**Consultation Response from KC,
Highways Development Management**

2021/91046 Building on junction of, Beaumont Street/William Street, Huddersfield, HD1 6BG

Erection of single storey extension to side, new photo voltaic panels to roof, mezzanine to form first floor and alterations to front boundary wall

Date Responded: 24/06/21 Responding Officer: CNB Responding Ref: K5-8SE/16

11 Front Proposed
1 : 100

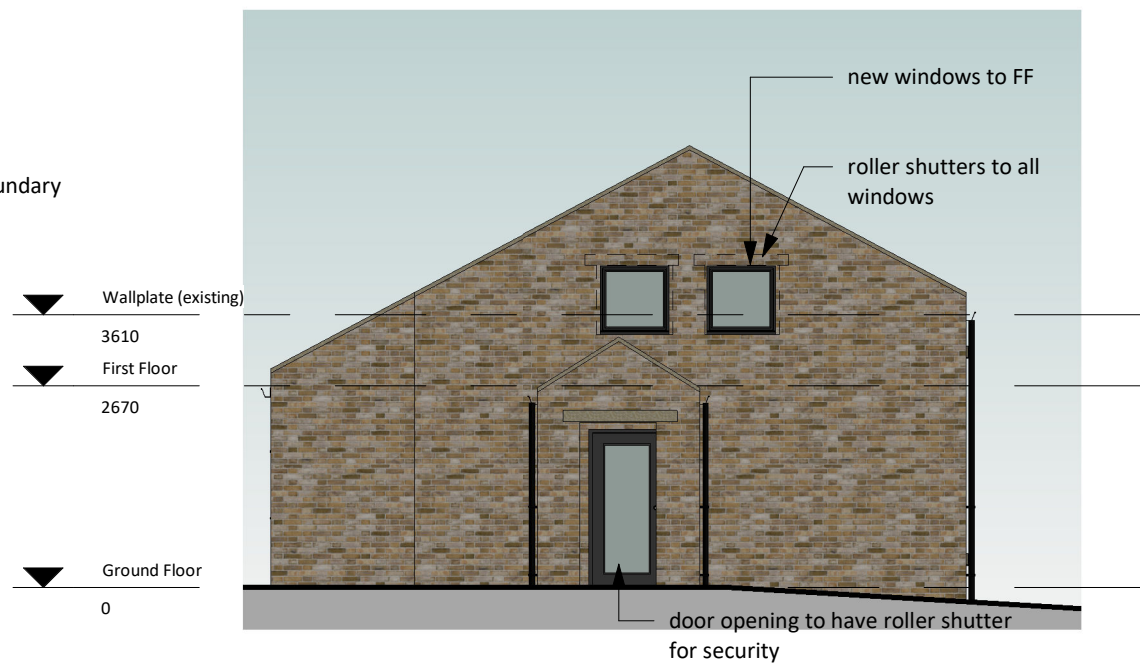
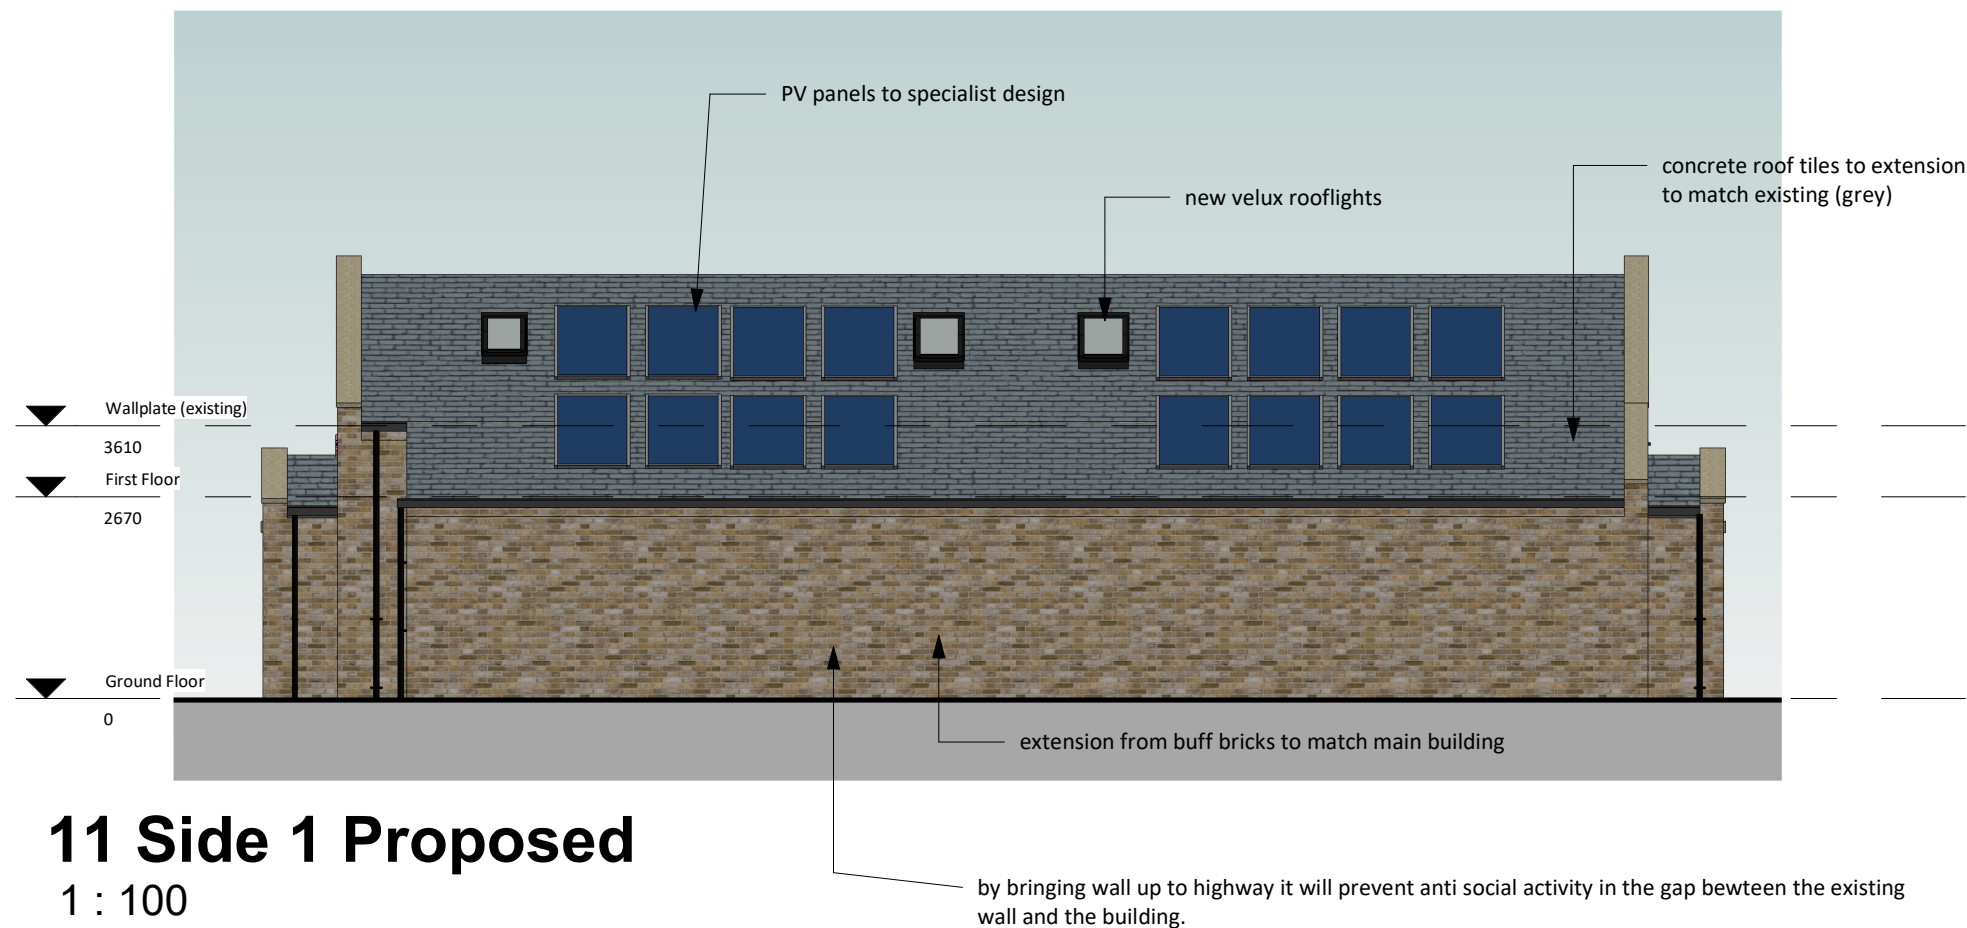
The existing wall around the open area to the south of the building is to be rebuilt to a height of 1.8m for security reasons. This should have no impact on the highway visibility at the junction of William St and Beaumont St as the wall is already existing and above 1m in height and therefore the existing visibility will not be made any worse. There are no record of any accident collisions at the junction and so we must assume that the highway is working safely and the existing wall is not causing any safety issues.

02b GF Proposed

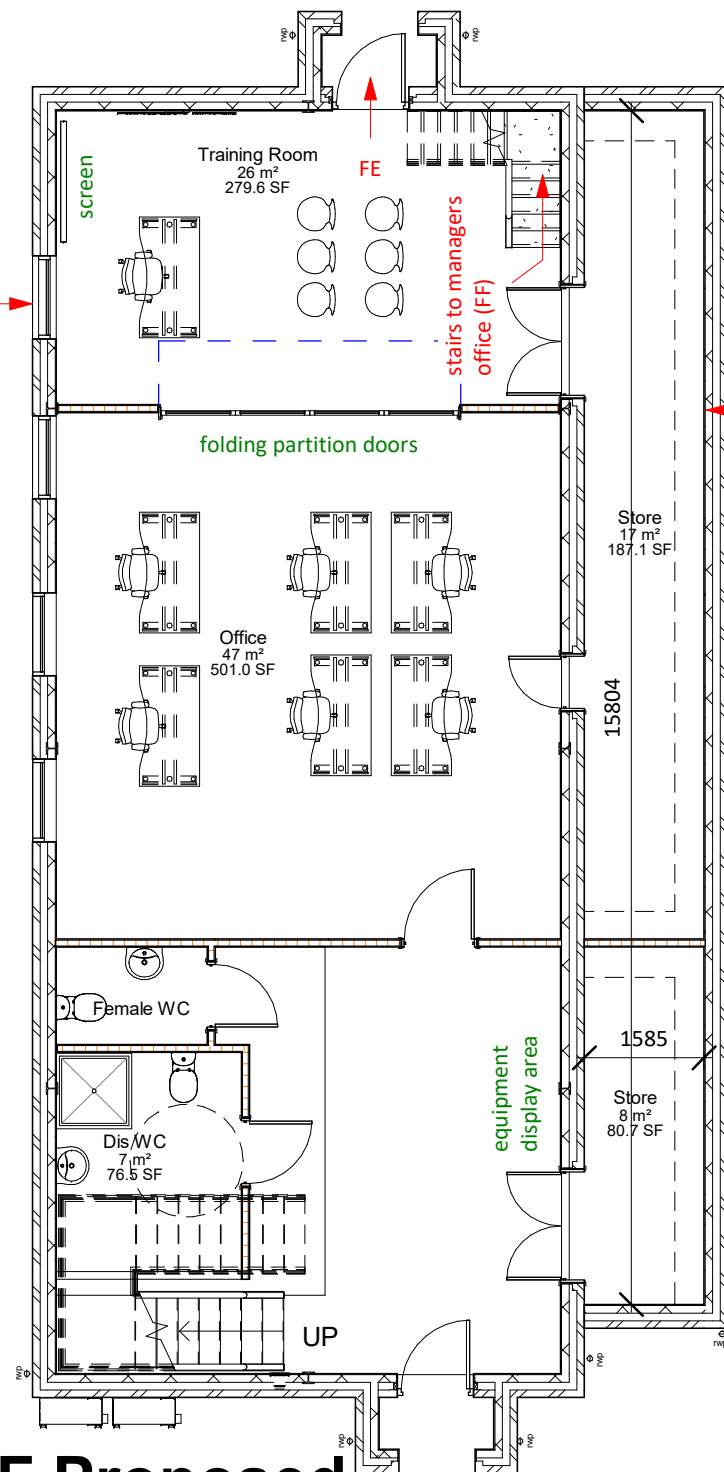
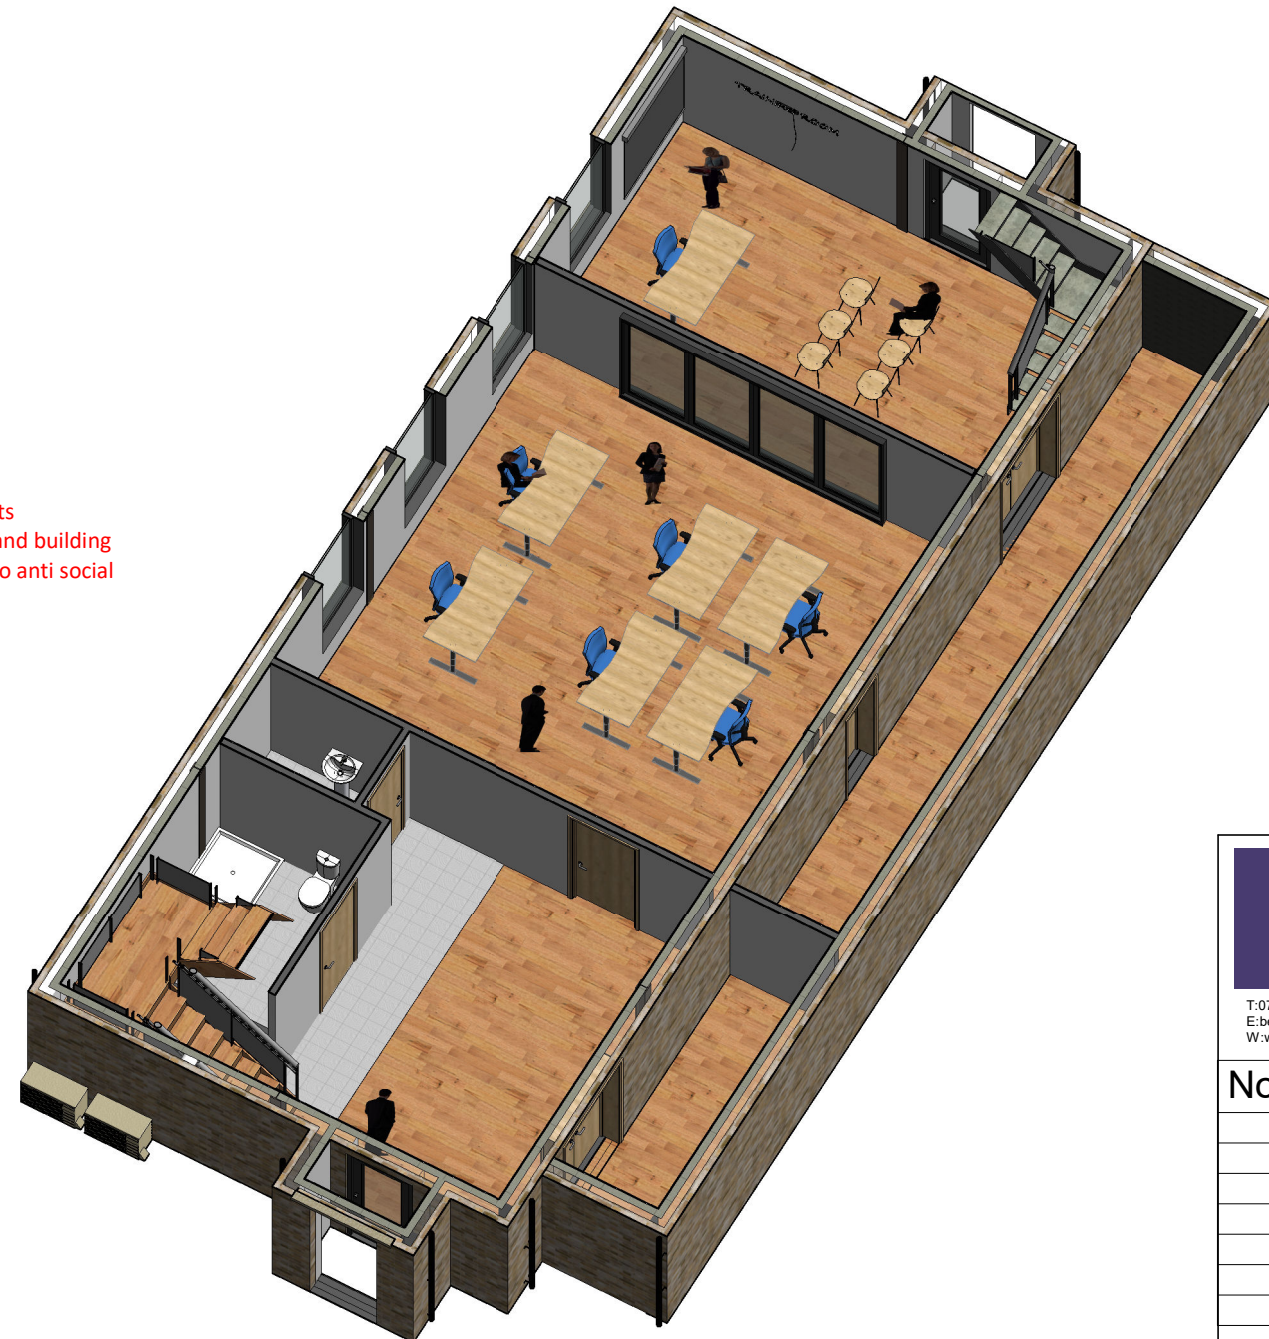
The proposals are to use the building for B1 office use with a studio space (shown in drawing J21-007 as a fitness studio) and the application form states that there will be 5 full time staff, however the drawing suggests the site may cater for more than 5 staff with 7 desks and a training room shown on the drawing. No details of the exact use of the site were provided.

00 Site Plan - Proposed
1 : 200

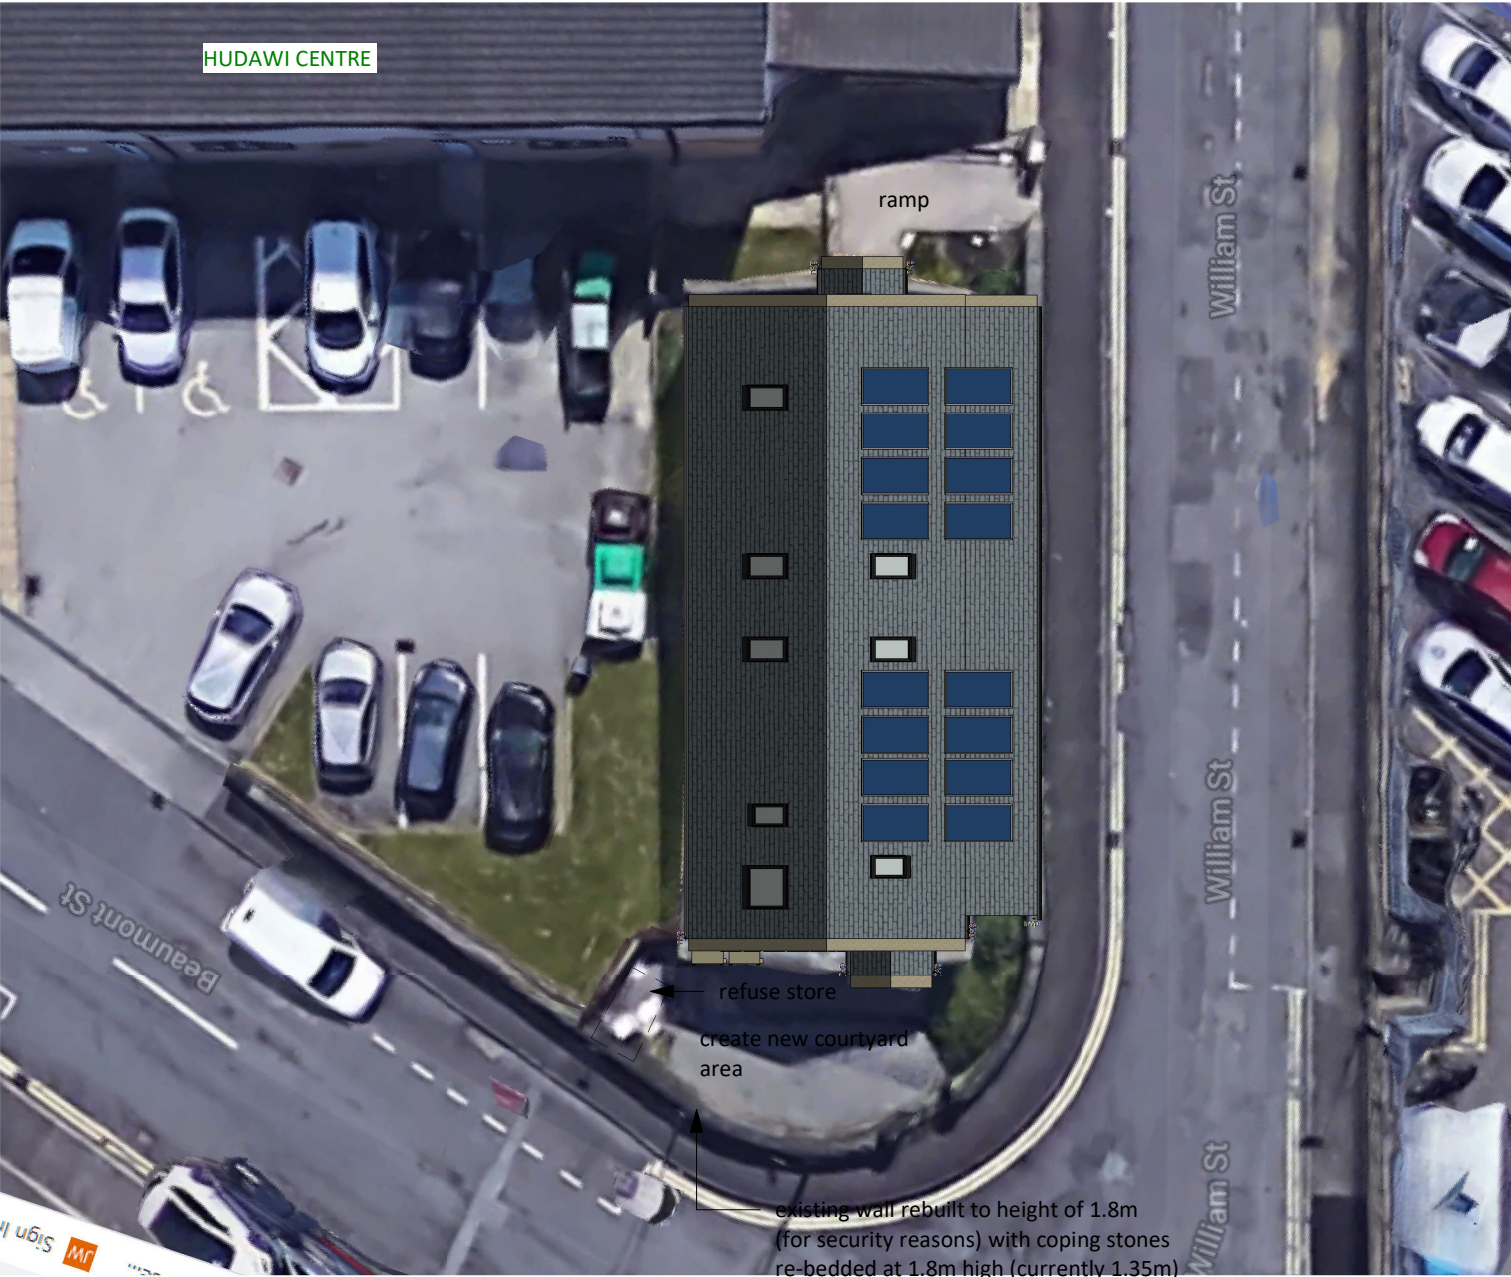
A refuse store is marked on the 00 Site Plan – Proposed drawing to the south of the building with a gated access on to the junction of William St and Beaumont St and this is acceptable.
